Re: Application for non-material amendment to Planning Permission S6/2006/137/FP
Property: 40 The Ridgeway, Cuffley, HERTS EN6 4BA

Your letter states that you wish to make a non-material amendment to Planning Permission S6/2006/137/FP which was granted for the demolition of the existing garage and erection of a double garage with store room over and glazed link to existing dwelling and erection of new front entrance gates. It is noted that the application seeks to increase the length of the approved garage structure by 1m on the front elevation of the property as shown on Plan no. 6792/P/150, revision D received and dated 20 October 2009.

Date June 2004
Scale 1:100 1:1250
Drawn mRn 6792/P/150 d

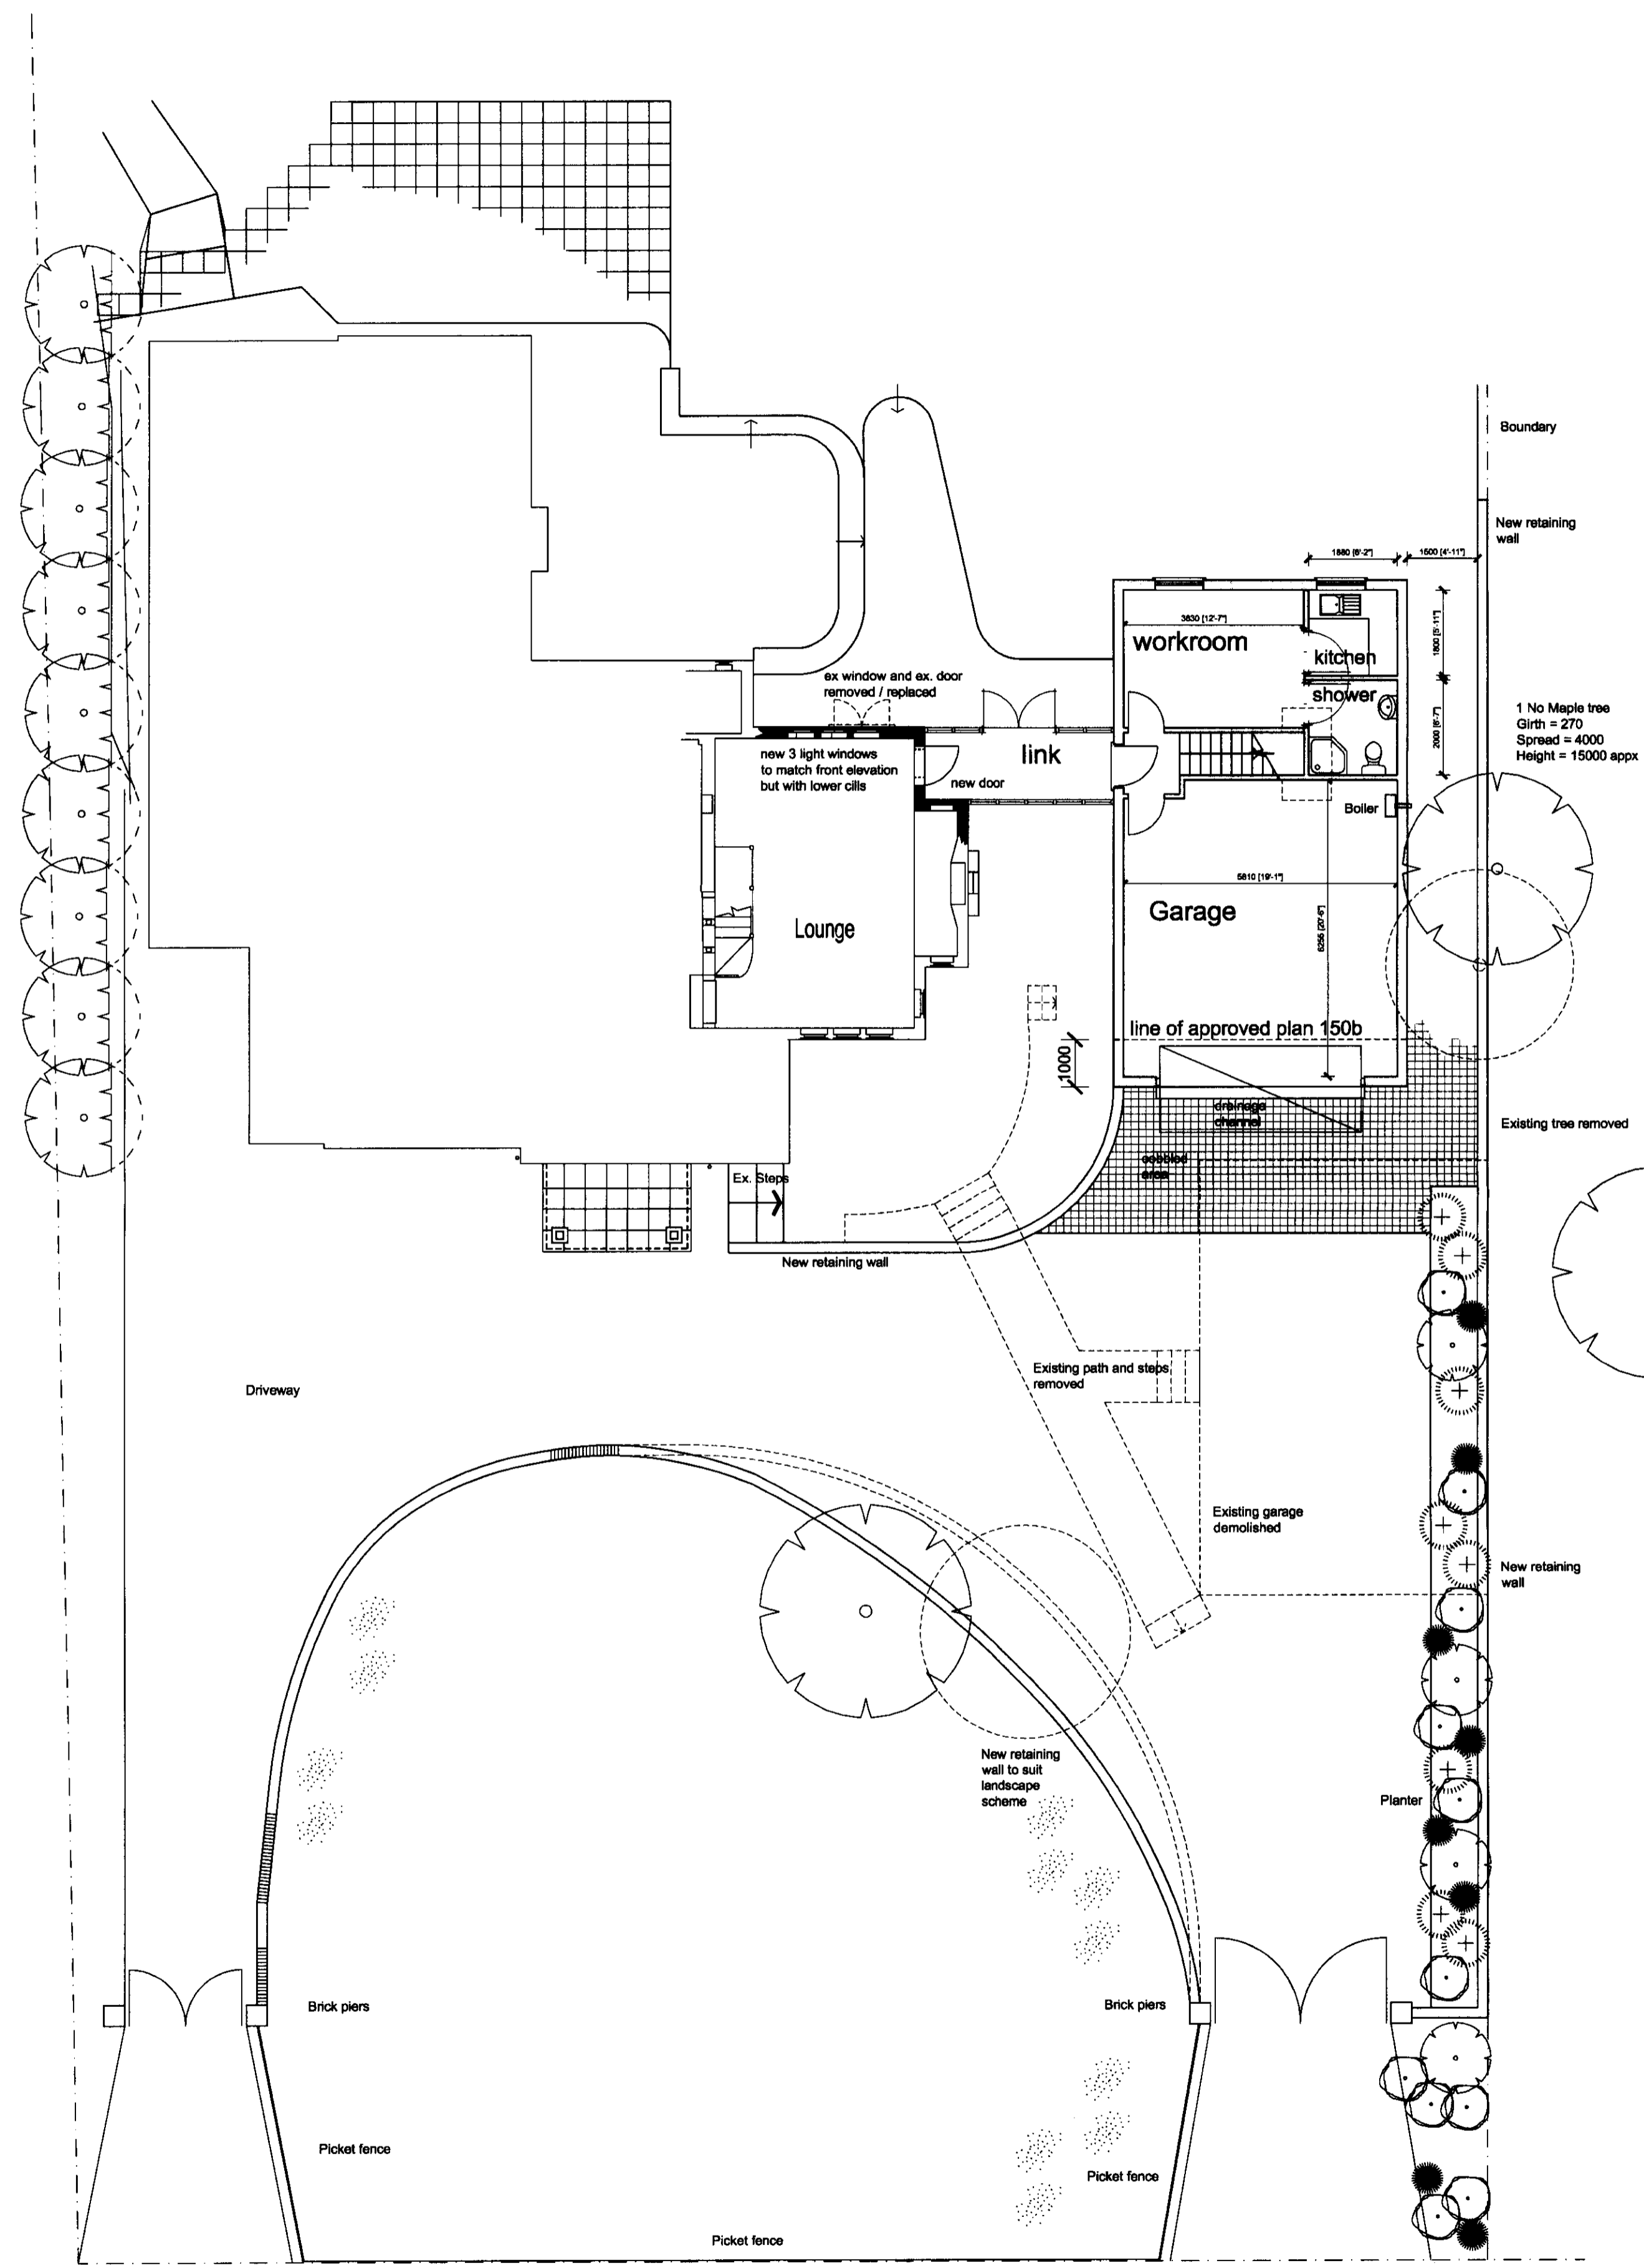
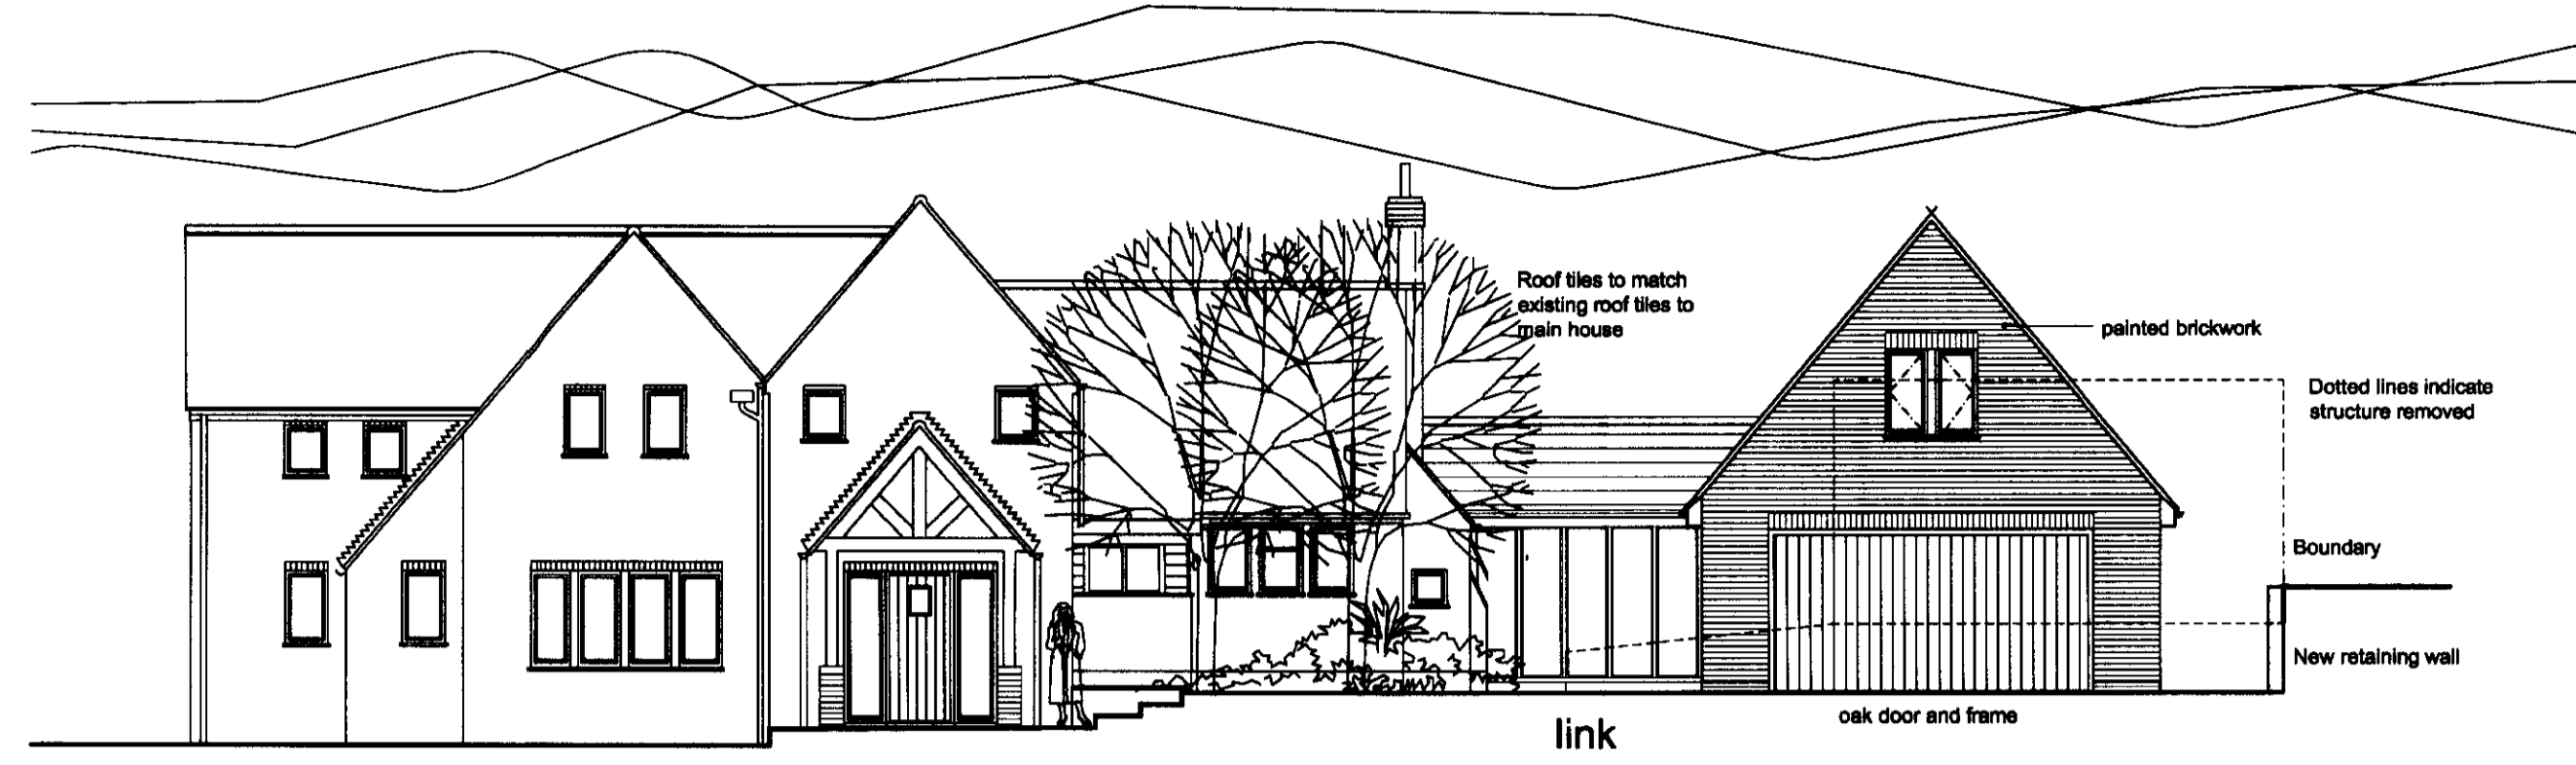
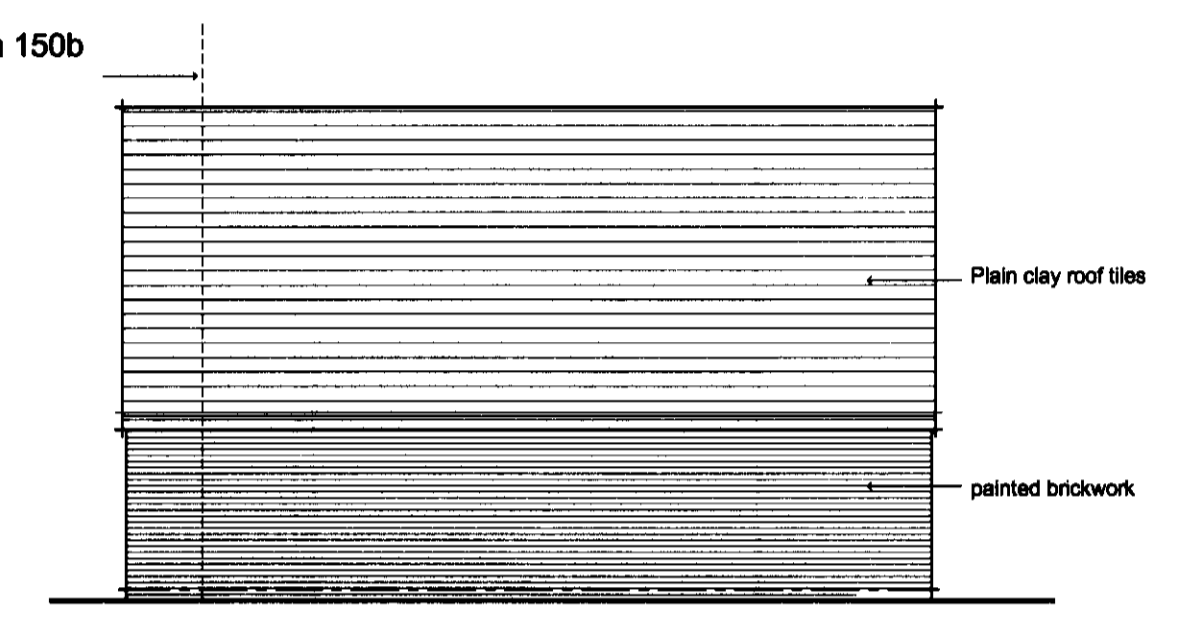
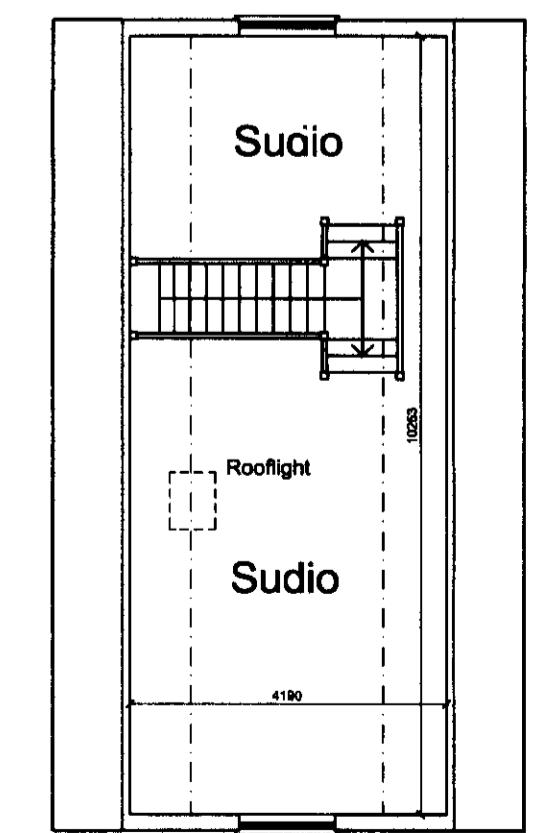
In this regard, it is considered that the above garage extension is not considered to be a non-material amendment and therefore the application is subsequently refused.

In addition, it is considered that the above amendment would not be considered a minor material amendment and subsequently a formal planning application would be required to be submitted for assessment. It is considered however that the proposal would not be in accordance with Council's policies and Planning Guidance 2: Green Belts given the area of extensions already permitted on site and Council would be unlikely to support the application.
